21 May 2025

TfNSW Reference: SYD24-01526/04
DPHI Reference: SSD-50972718

**RESPONSE TO SUBMISSIONS FOR WALLGROVE BUSINESS HUB
97-151 WALLGROVE ROAD, CECIL PARK**

Figure 1: Proposed access arrangement.

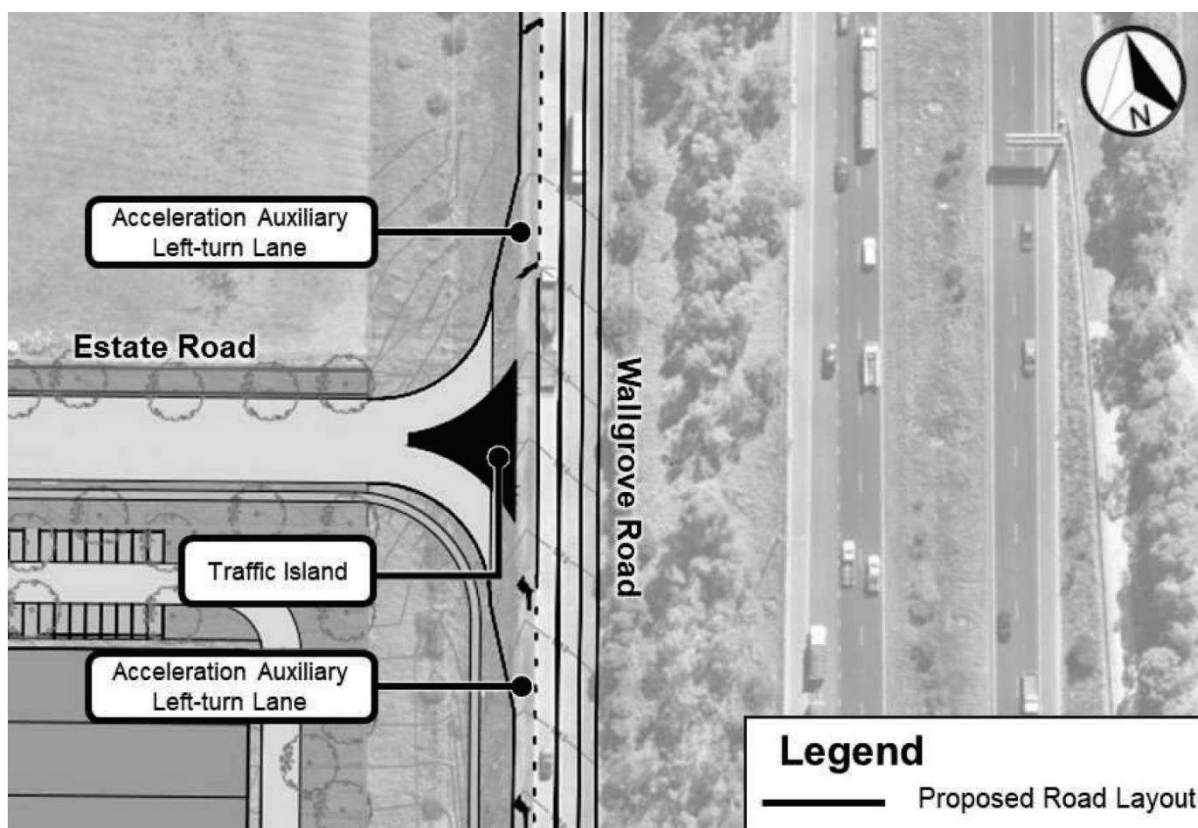
TfNSW notes that the Applicant has removed the acceleration as per the previous TfNSW response, however, advises that the deceleration lane provided in the civil plans is not compliant with Austroads.

The deceleration lane is shown as 102 metres long including taper, when it should be 125 metres long and designed for a stop condition with a design speed of 90km/h, due to pedestrian crossings shown on the plans. TfNSW advises that in addition to being compliant with Austroads, the design will also not preclude future active transport.

As all proposed civil works on Wallgrove Road (**classified road**) require separate TfNSW concurrence under section 138 of the *Roads Act, 1993* and the Applicant to enter a Works Authorisation Deed (**WAD**) with TfNSW for the civil works, TfNSW require the Applicant to provide civil plans that are compliant with Austroads.
